Proposed Application by Keuper Gas Storage Limited for an Order Granting Development Consent for the Keuper Gas Storage Project

The Planning Inspectorate's comments on the Applicant's pre-application core draft documents

EN030002 - Keuper Gas Storage Project

Planning Inspectorate's comments on core draft application documents submitted in September 2015.

**HOLFORD BRINEFIELD - KGSP - ABOVE GROUND
WORKS PLAN [REGULATION 5(2)(I)] - SHEET 9 OF 9**

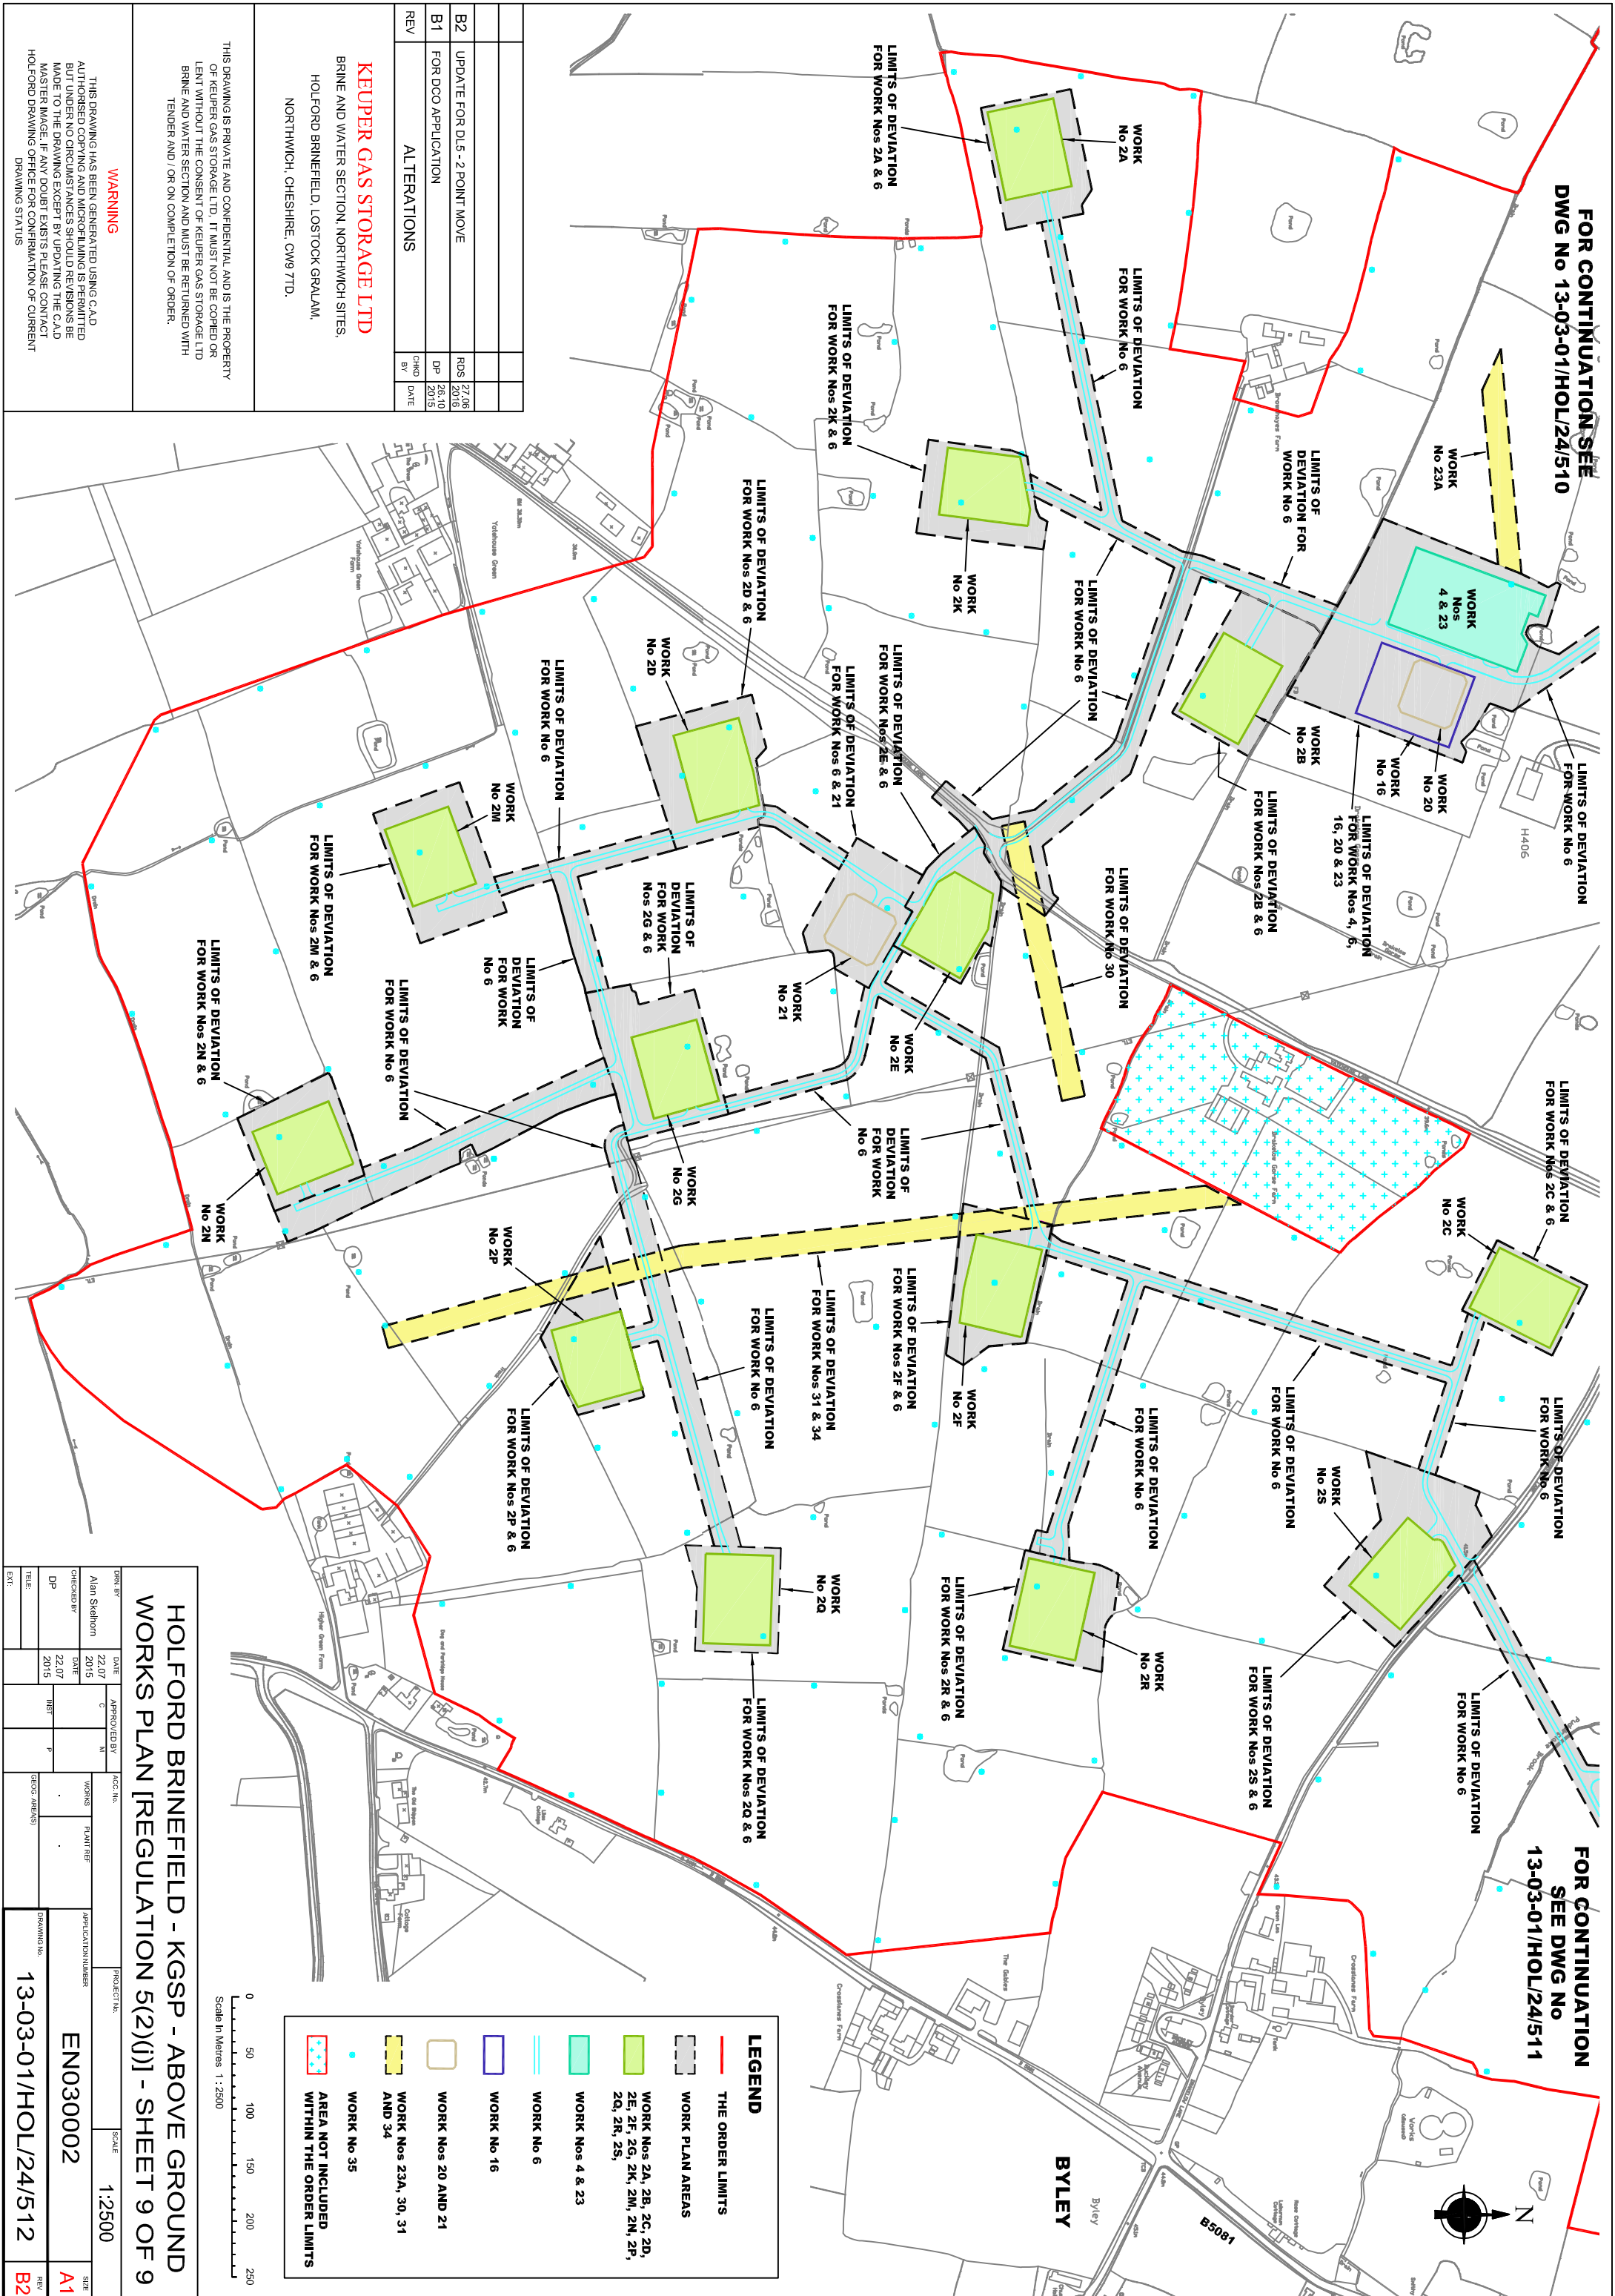
Works Plans – sheets: 500–506 & 510-515

- The Works Plans submitted to the Planning Inspectorate in September 2015 improve on previous versions, especially with regard to the level of detail and use of colour.

- It appears that the Applicant produced two set of Works Plans, one showing above ground works and one showing underground works. If this approach is to be continued with, it would be helpful to clearly state in the plan title that it depicts either above or below ground works.

- While this approach does have benefits with regard to clarity, it does make identifying how works fit together more difficult.
- An example of this can be observed on plan 504, where Work No 13 (underground pipeline) connects Work No. 12 (Connection to Gas NTS compound) and Work No 14 (gas processing plant). As Works No 12 & 14 are not shown on the 'underground' plan (504) it requires utilising both plan 504 and also plan 510 to observe the work.

- One way in which the approach used could be improved would be to have an outline on the underground plans of the above ground works. This could be done at

their maximum limits of deviation (maybe with a note to state that this is for ease of reading and that reference should be made to the over ground plan for a detailed depiction of the work.)

- Although the plans are easier to read, it is often hard to pinpoint exactly where a work begins and ends. Part of the issue is because of the difficulty in having some works depicted on two separate sheets (above / underground). It would also be of great help if, for example, pipelines could have a small identifier of the Work Number at each end of the work. Using the same colour for the label would also aid clarity.
- Work No 19 – In the BoR there are three separate works (19A, 19B & 19C) but on the Works Plans (sheets 504 & 506) these are shown as just Work No 19. Please separate these on the Works Plans so that they reflect the works as listed in the BoR.
- Work No 8 – This work appears at all the cavity sites (A1 - 1U). Should the same work appear multiple times? If these are separate works, could these 'vertical wells' be included within the works numbered 1A - 1U?
